Re: Uptown-Sandia View Assisted Living
8211 Cutler Avenue NE
Traffic Circulation Layout
Architect's Stamp 02-04-20 (H19-D089)

Based upon the information provided in your submittal received 03-09-20, the above referenced plan cannot be approved for Building Permit until the following comments are addressed:

SHEET NUMBER:
TCL-101

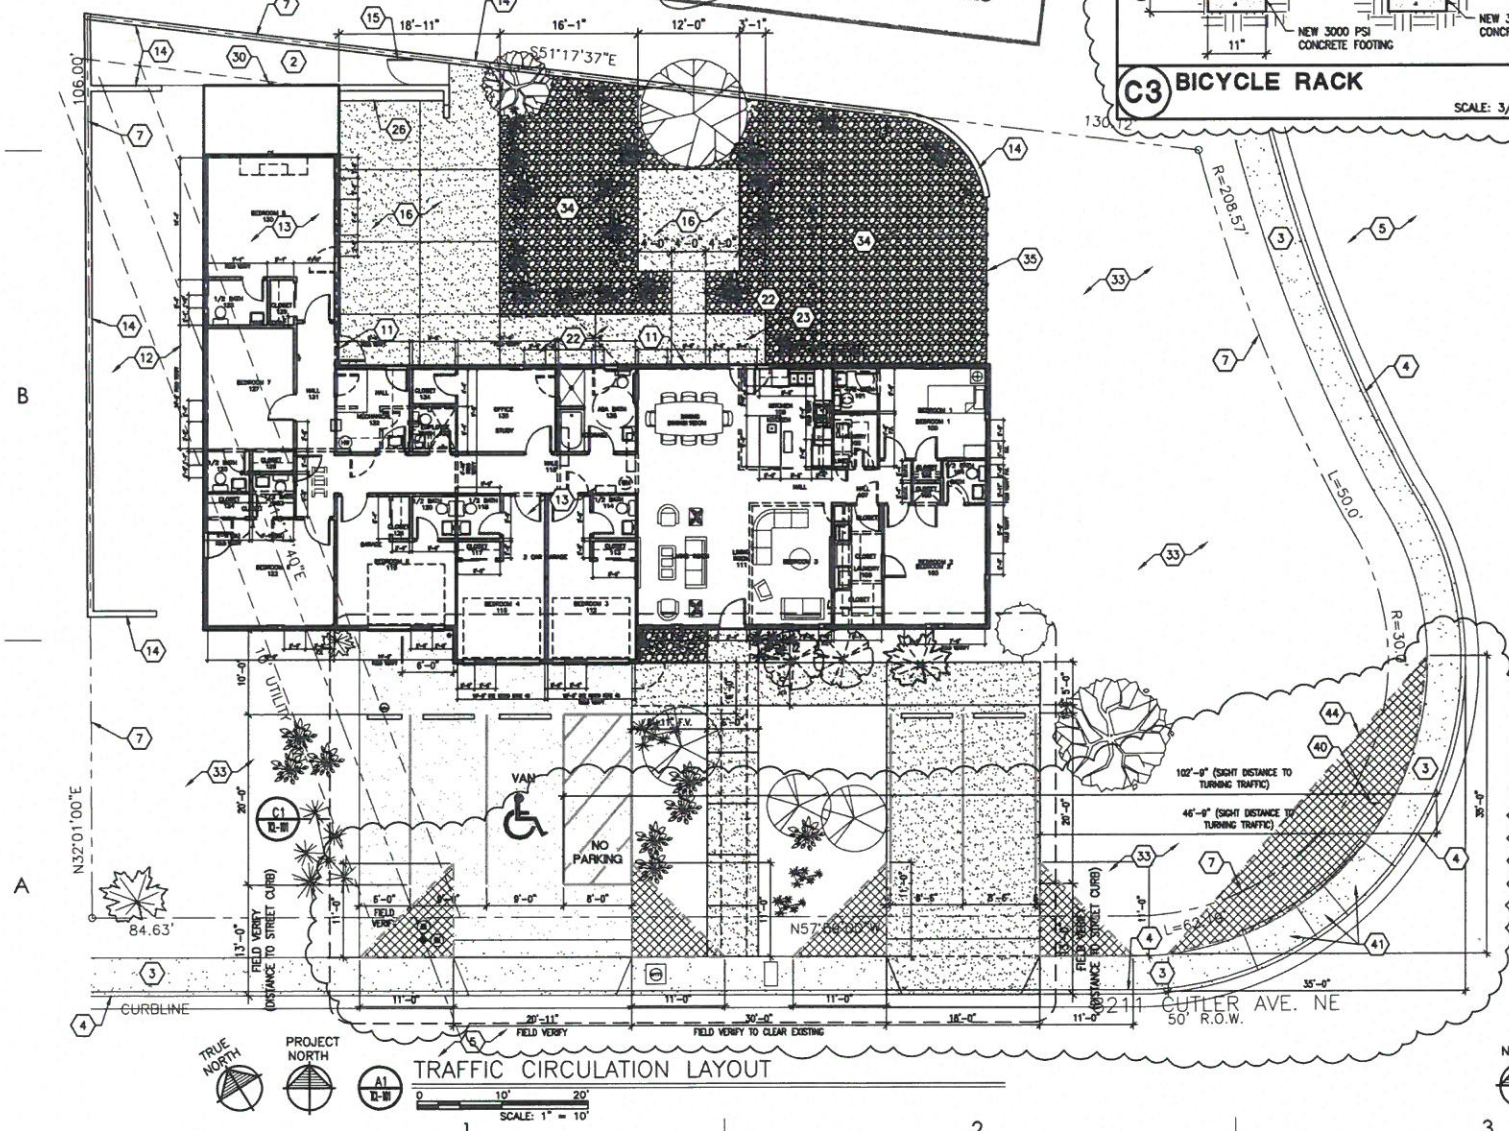
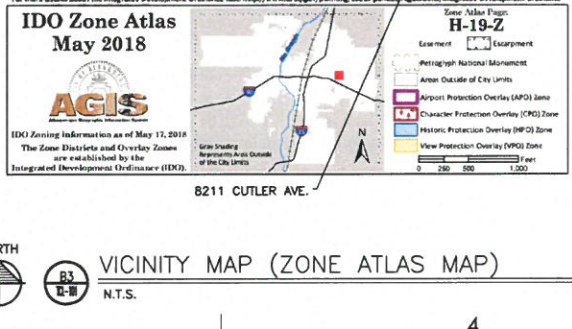
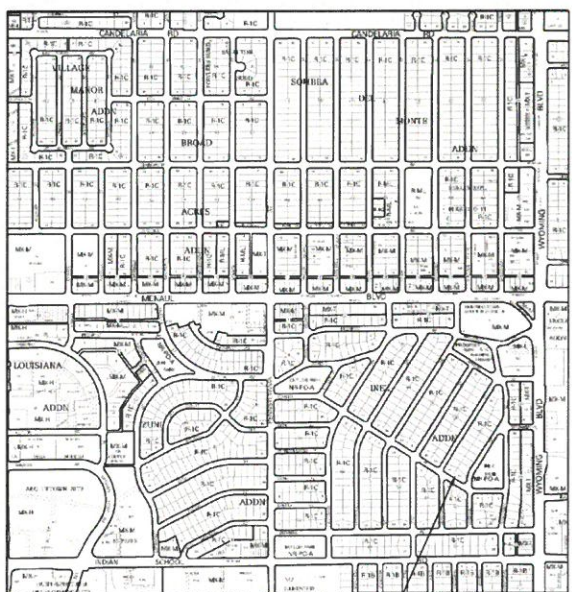
1. Please coordinate all calculations for parking spaces including bicycle, and motorcycle parking with Zoning.
2. Identify existing ADA ramp at corner of Cutler and Virginia. The ramp must be updated to current ADA standards and have truncated domes installed easements and rights of way width dimensions.

3. The ADA accessible spaces must include an access aisle. Van accessible aisles should be 8ft wide; all others should be 5ft wide. Notes 19 and 32 must be painted blue (only in reference to ADA parking spaces).

4. Per the IDO, a 6 ft. wide ADA accessible pedestrian pathway is required from the public sidewalk to the building entrances. Please clearly show this pathway and provide details.

5. Per DPM, a 6 ft. wide ADA accessible pedestrian pathway is required from the ADA parking stall access aisles to the building entrances. Please clearly show this pathway and provide details.

6. Curbing should be installed to delineate landscape, parking, and pedestrian ways and identify points of access. Please call out detail and location of barrier curb.

7. Provide detail for parking bumpers (note 31).
8. The minimum drive through lane width is 12 feet with a 25 foot minimum radius (inside edge) for all turns. (A 15 foot radius can be used with an increase in lane width to 14 feet). Please dimension all lane widths and radii.

9. Please provide a sight distance exhibit
10. Show the clear sight triangle and add the following note to the plan:
"Landscaping and signage will not interfere with clear sight requirements.
